Application reference number	2025/0930
-------------------------------------	-----------

Application Type	Variation of Condition
-------------------------	------------------------

Proposal Description:	Variation of condition 2, in relation to application 2020/1387 "Residential development of 7no. dwellings and associated works" to allow for amendments to house type D.
Location:	14 Roughbircworth Lane, Oxspring, Sheffield

Side Elevation 1 - Existing Approval Overlays

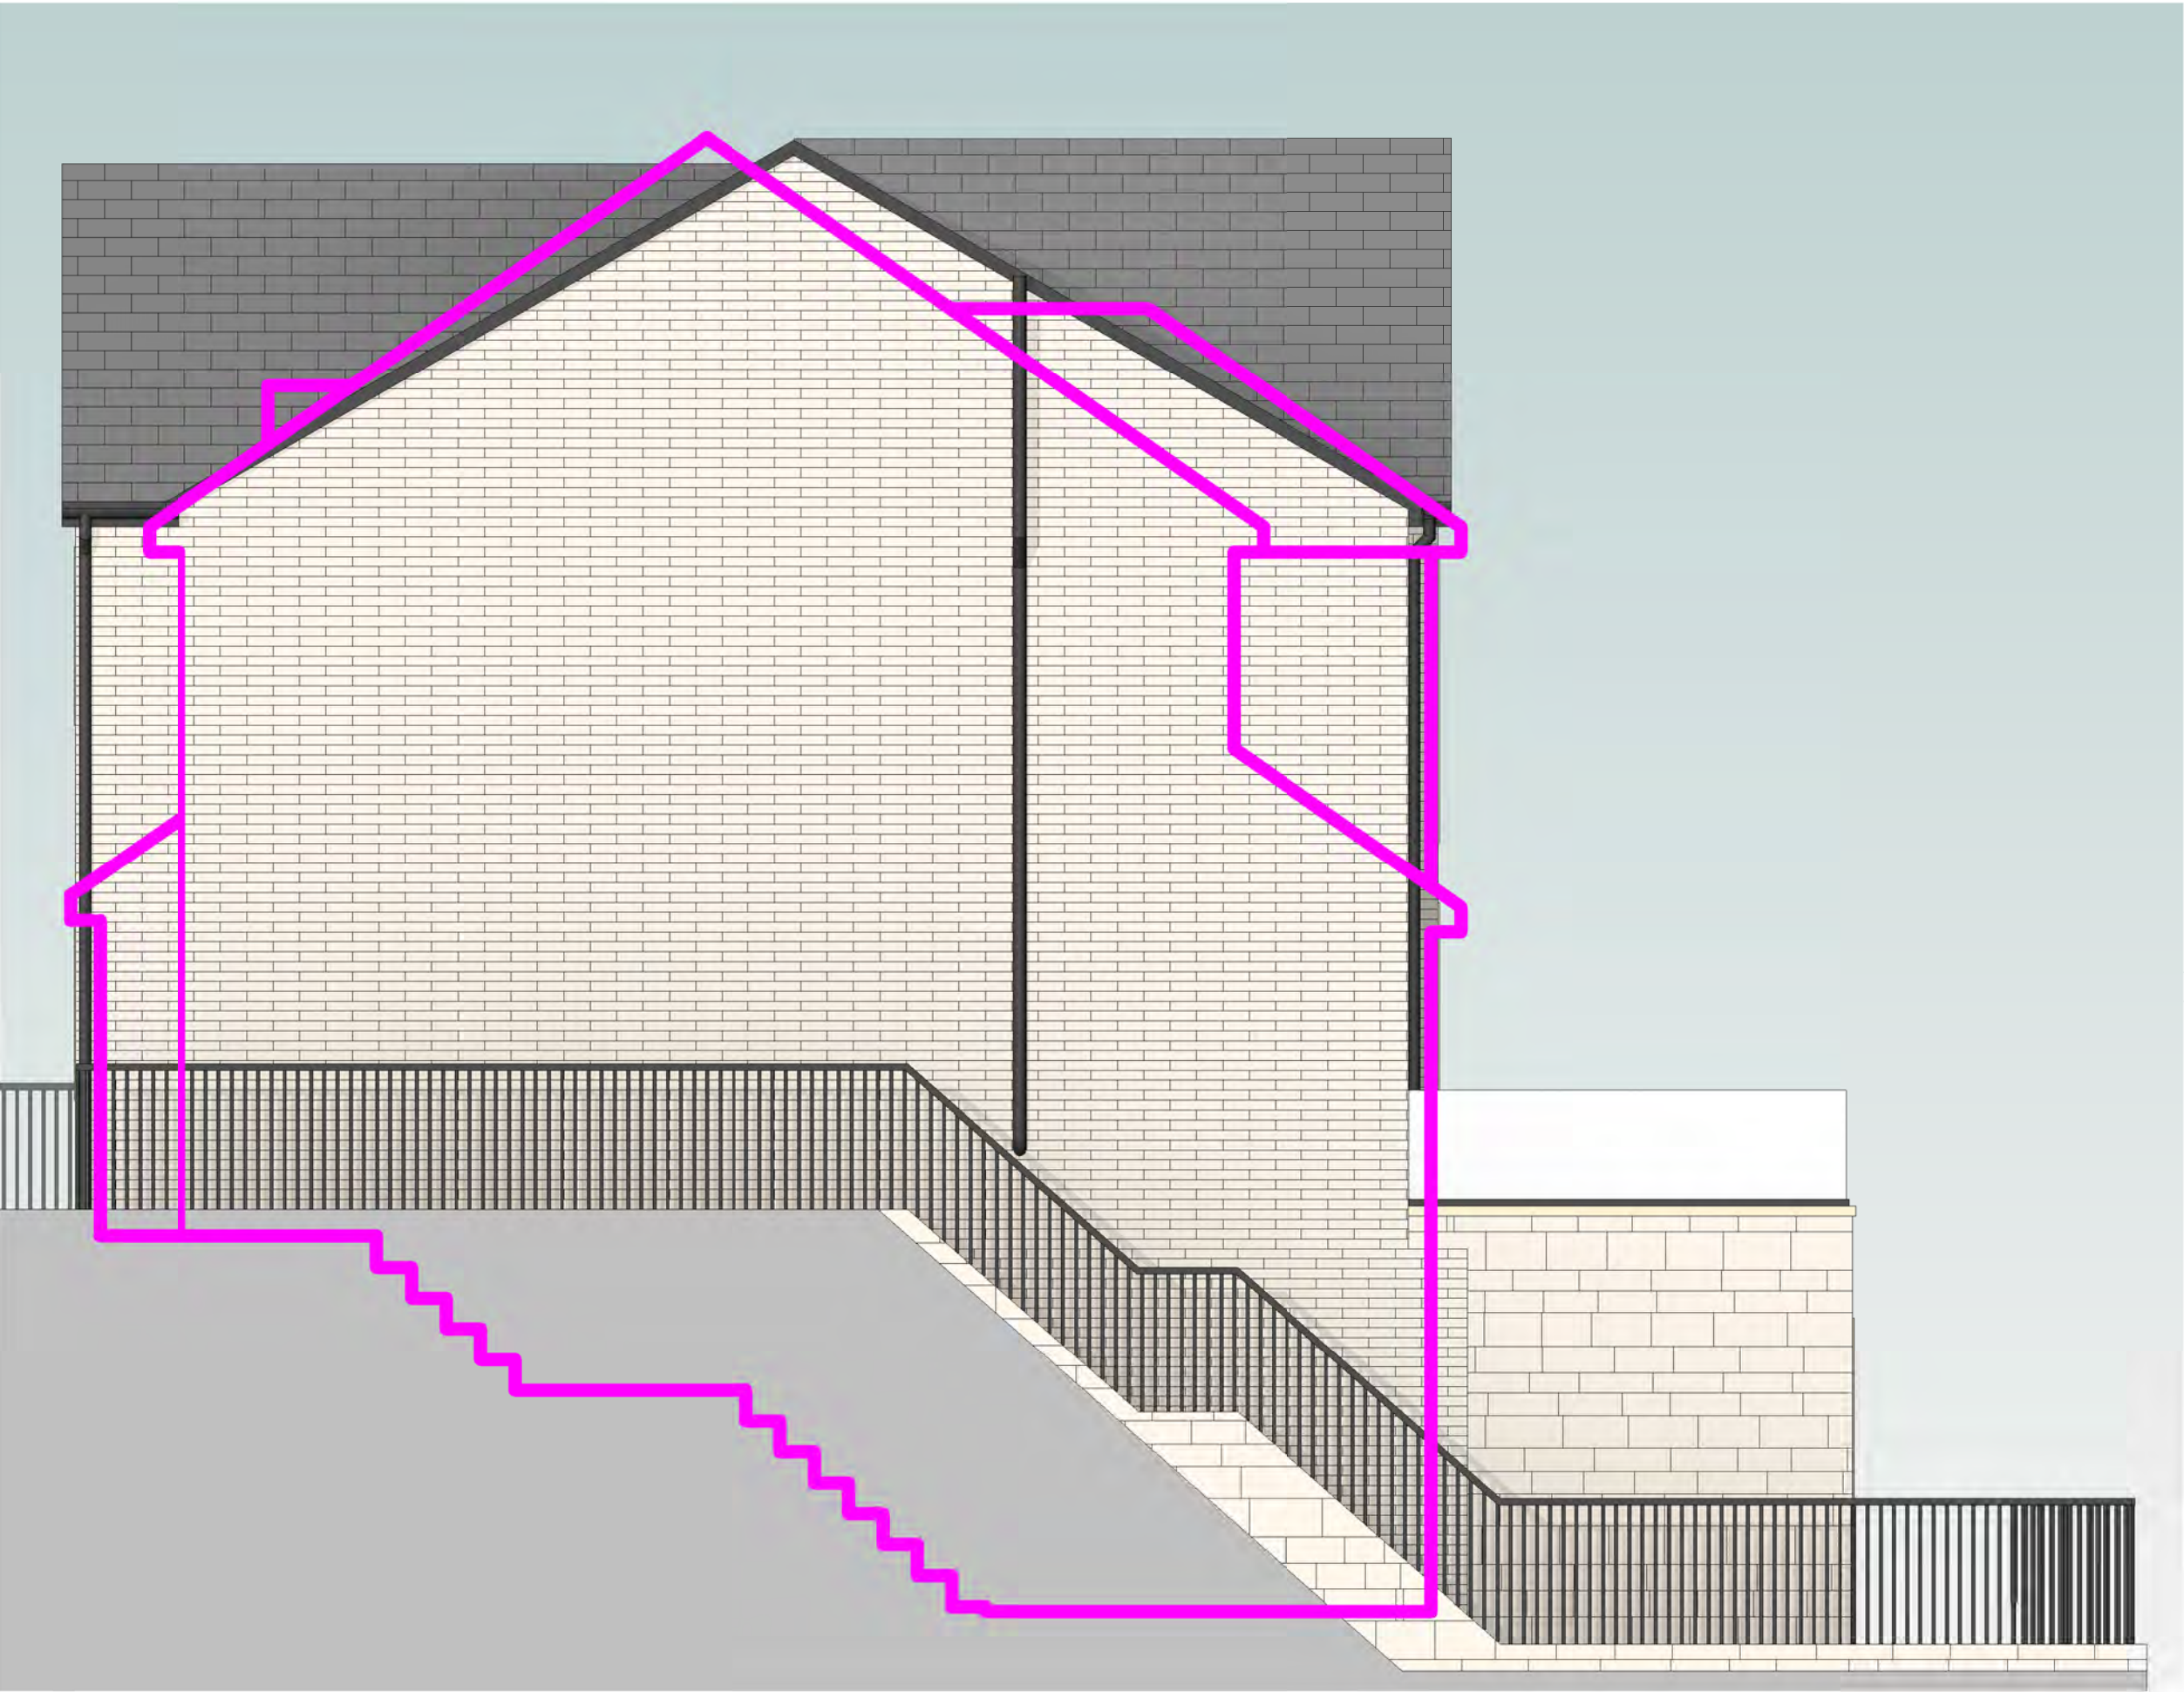
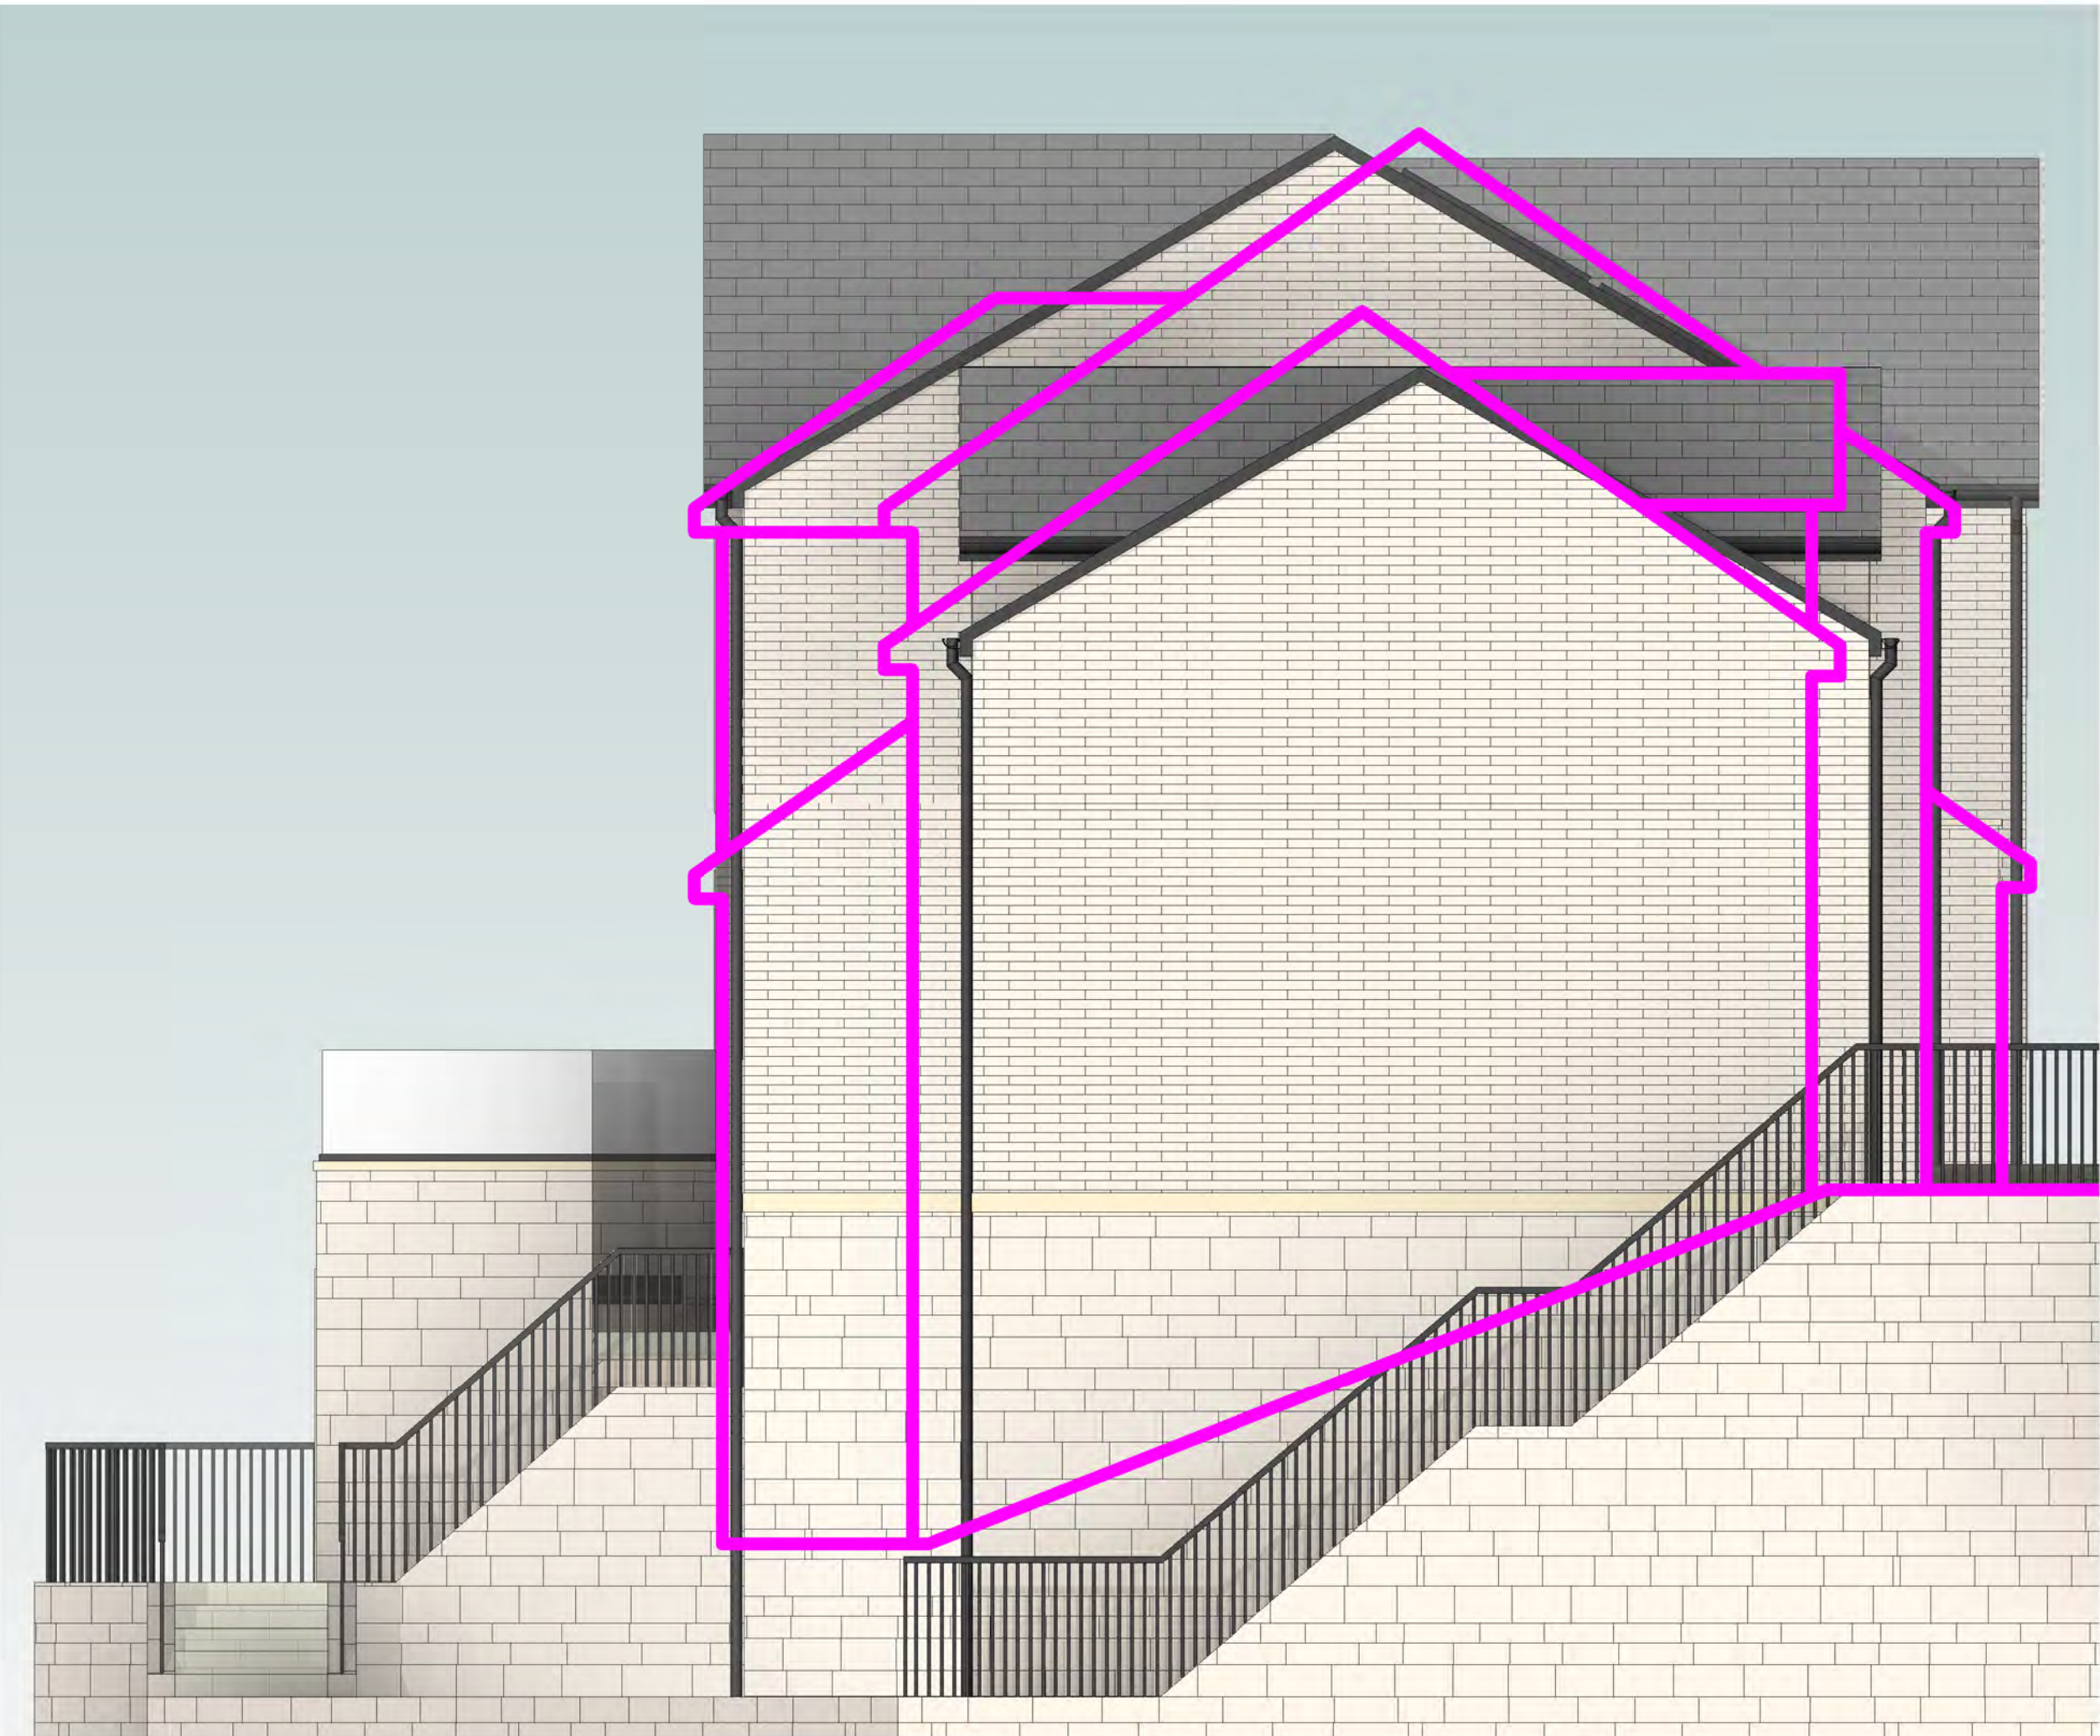
Concerns have been raised by neighbouring residents with regard to overlooking impact from additional windows and the proposed raised terrace area. A comparison of the house types is shown below. Whilst there are additional windows, the majority of the changes are set at lower ground floor level.

Turning to the rear terrace, this would not overlook the dwellings on Millstones significantly more than the existing windows or garden area at the plot. In terms of overlooking of the adjacent dwelling, the applicant's proposed dwelling and terraces are set back as can be seen on the proposed site plan below, and there are no habitable room windows impacted by the terrace in terms of overlooking or overbearing.
